**Premiere House, Elstree Way, Borehamwood, Hertfordshire, WD6 1JH**  
**Submission of Non-Material Amendment**  
**Portal Ref: PP-12778377**

This letter accompanies an application for a non-material amendment to permission reference 23/1280/FUL which was granted on 24/11/2023 for the following:

This application seeks non-material changes to the internal layout of the approved development as follows:

TITLE
GYM - Proposed Plan

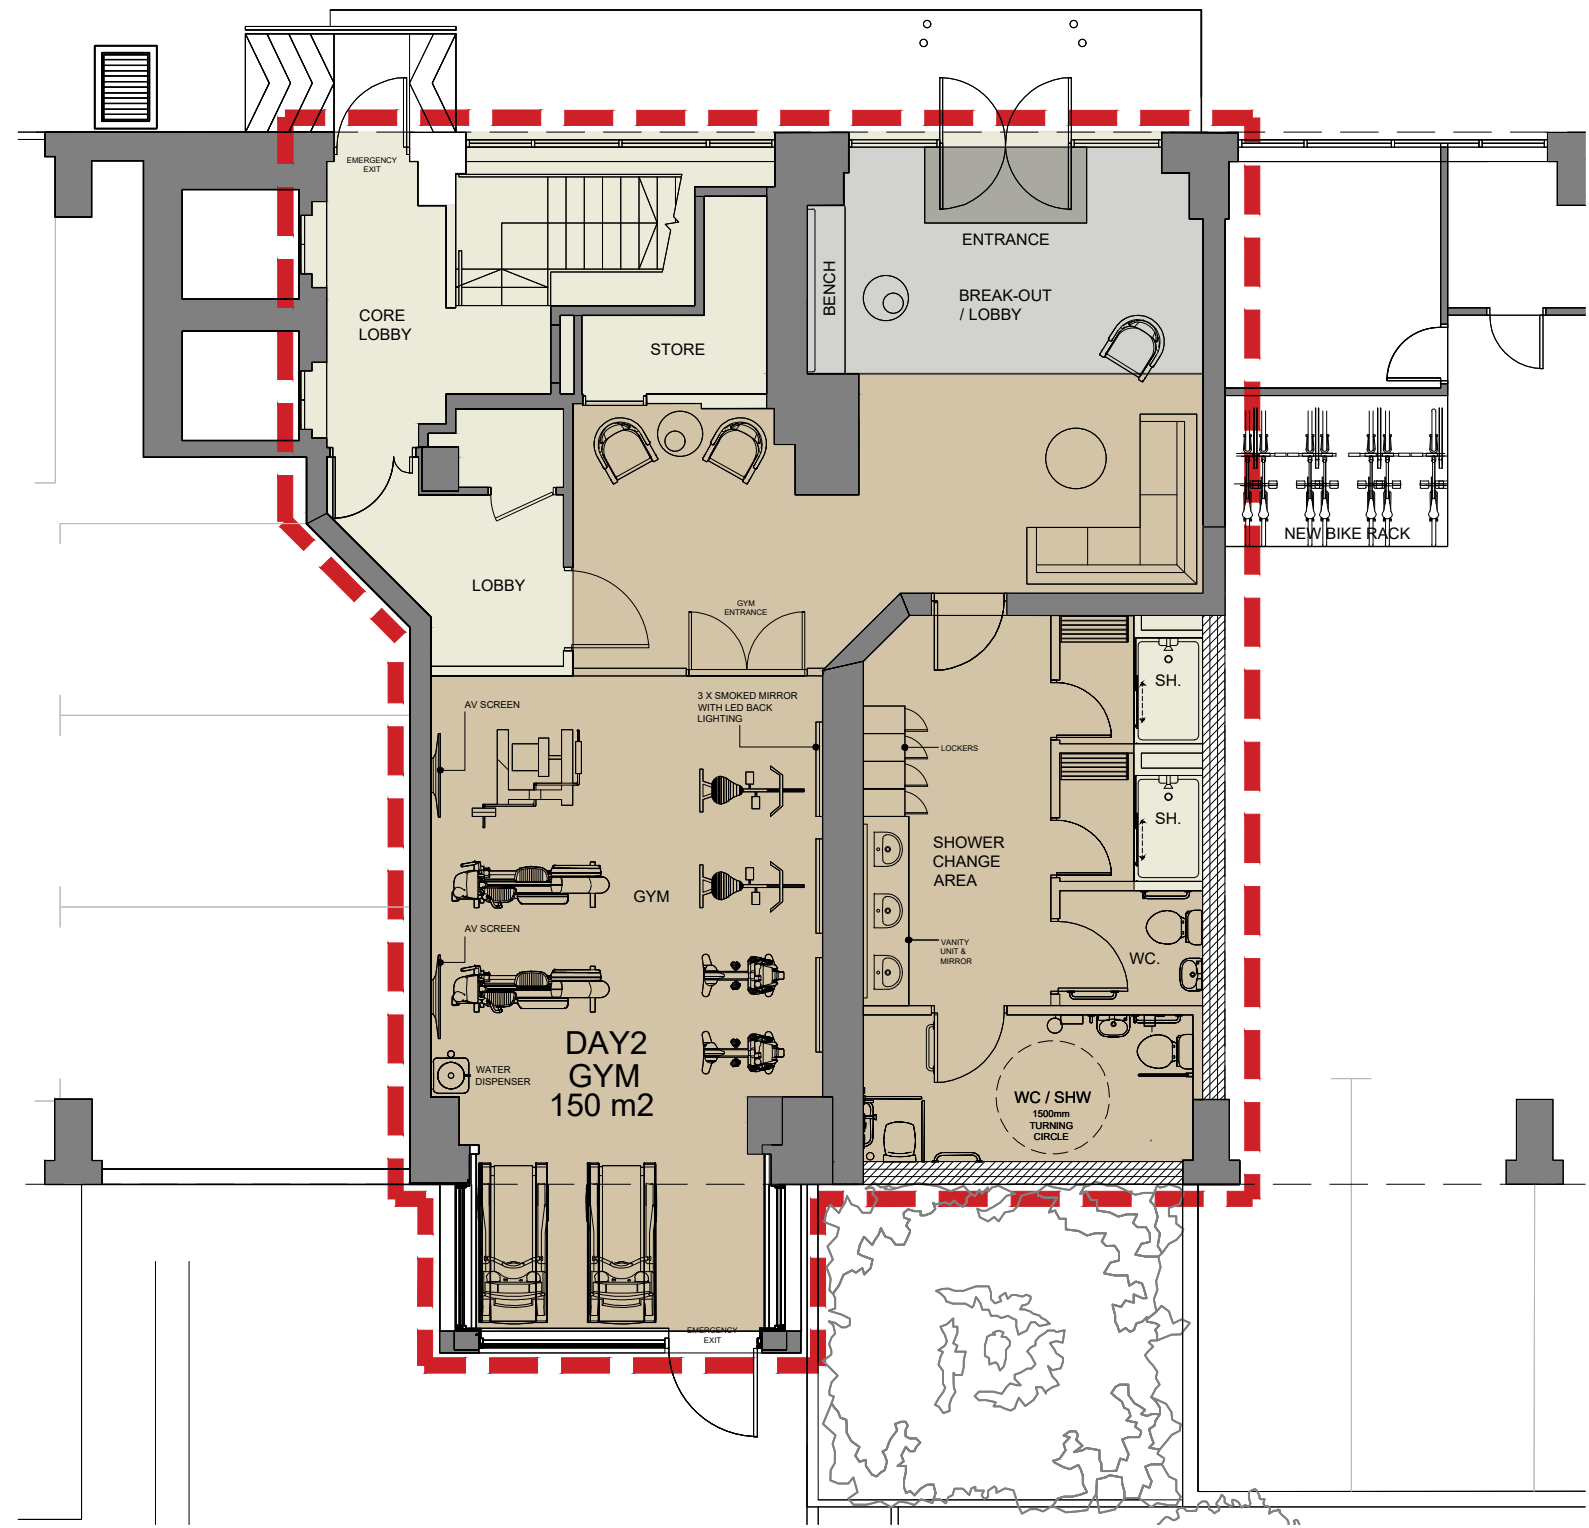
- Retention of internal structural walls.
- Re-location of internal partition walls and doors.
- Re-configuration of internal gym space and equipment position.

A comparison of the two plans is shown below. The structural walls proposed to be retained are outlined in red. Internal partition walls will be installed in the areas shown blue.

TITLE  
**GYM - 03 Demolition Plan**

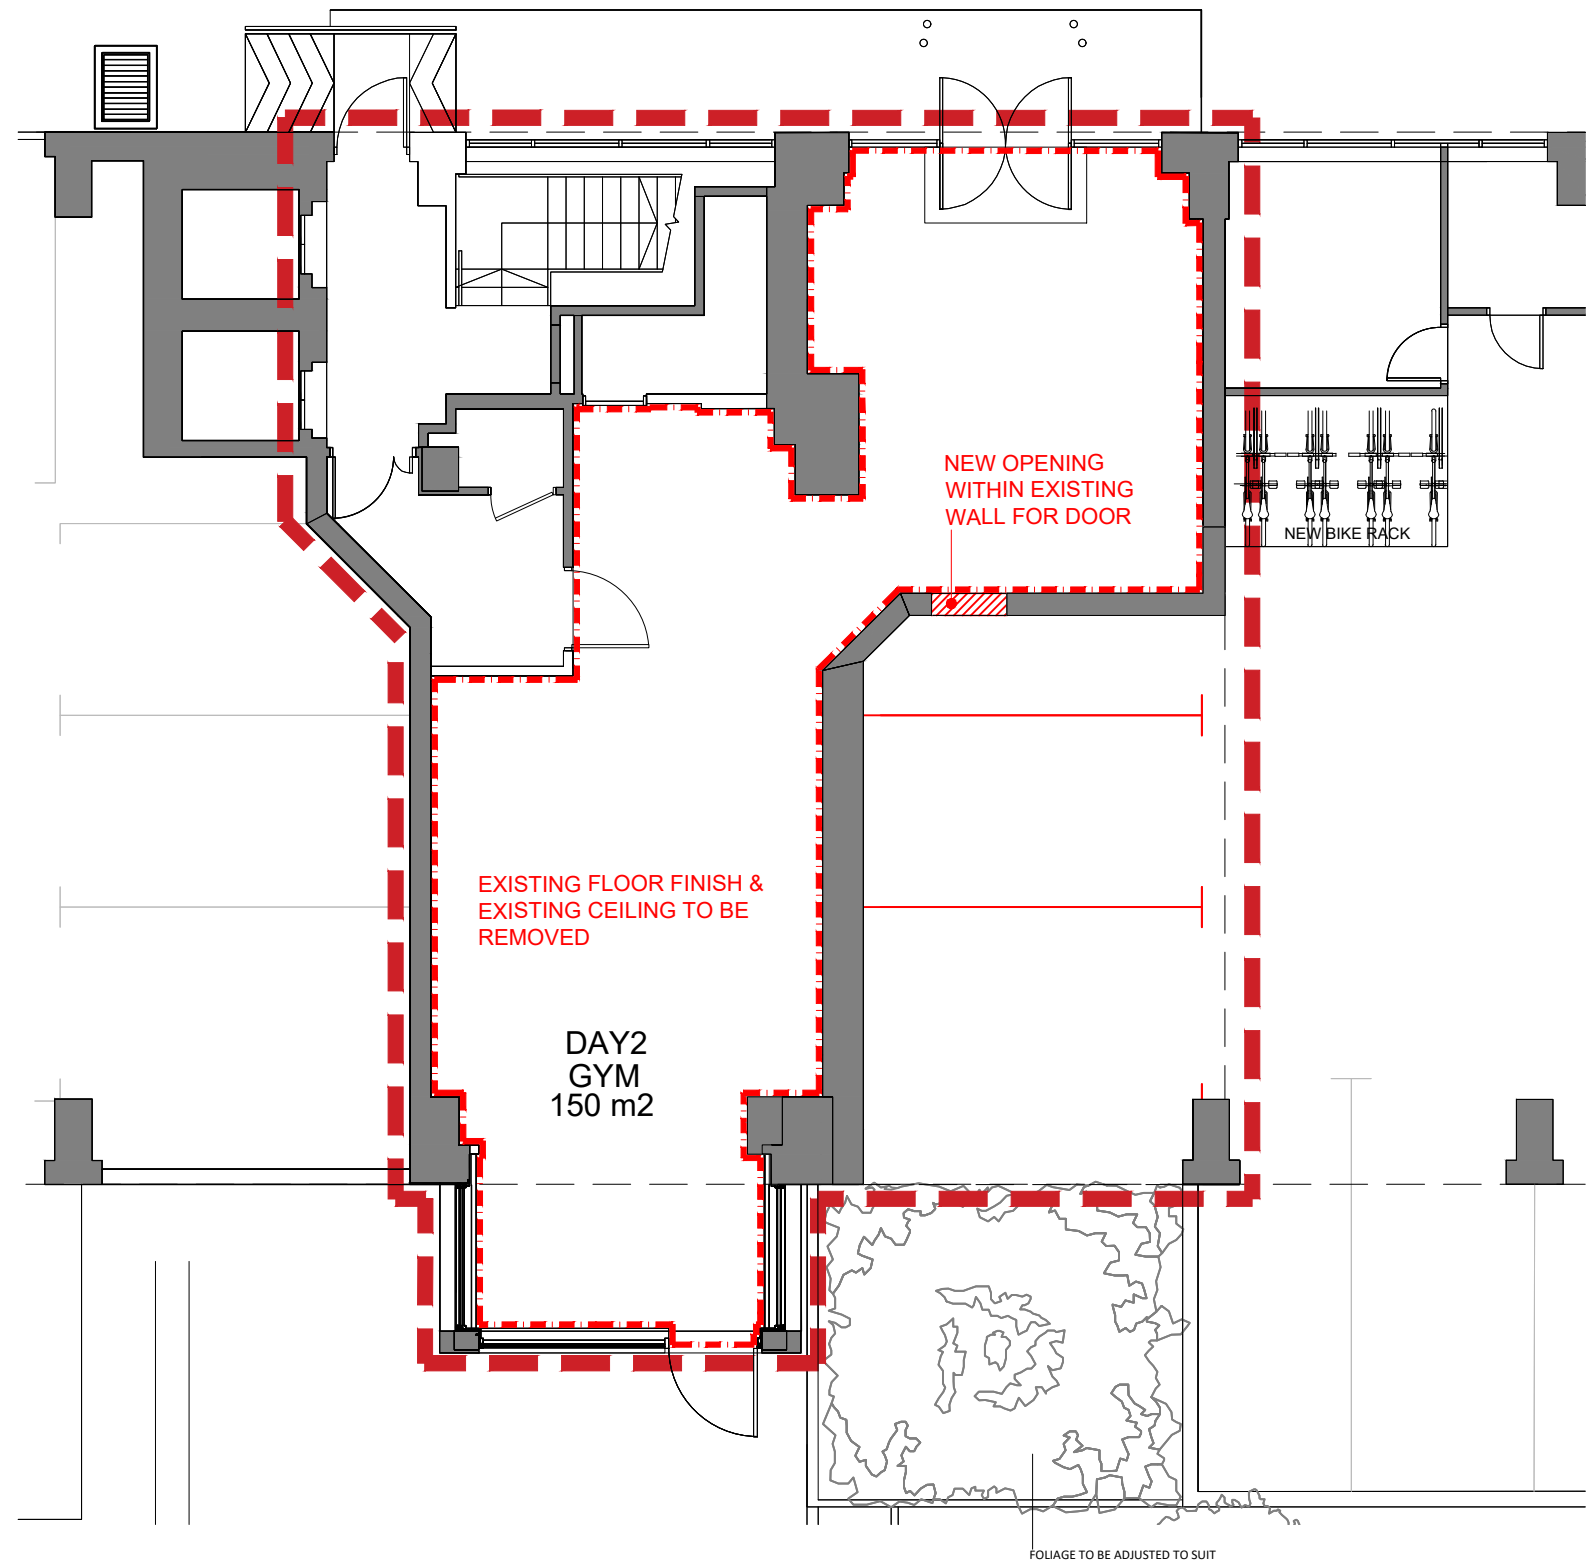
In addition, the amendments will result in the generation of less waste arising from the proposed development, with existing internal structural walls now retained as opposed to being demolished as approved under ref 23/1280/FUL.
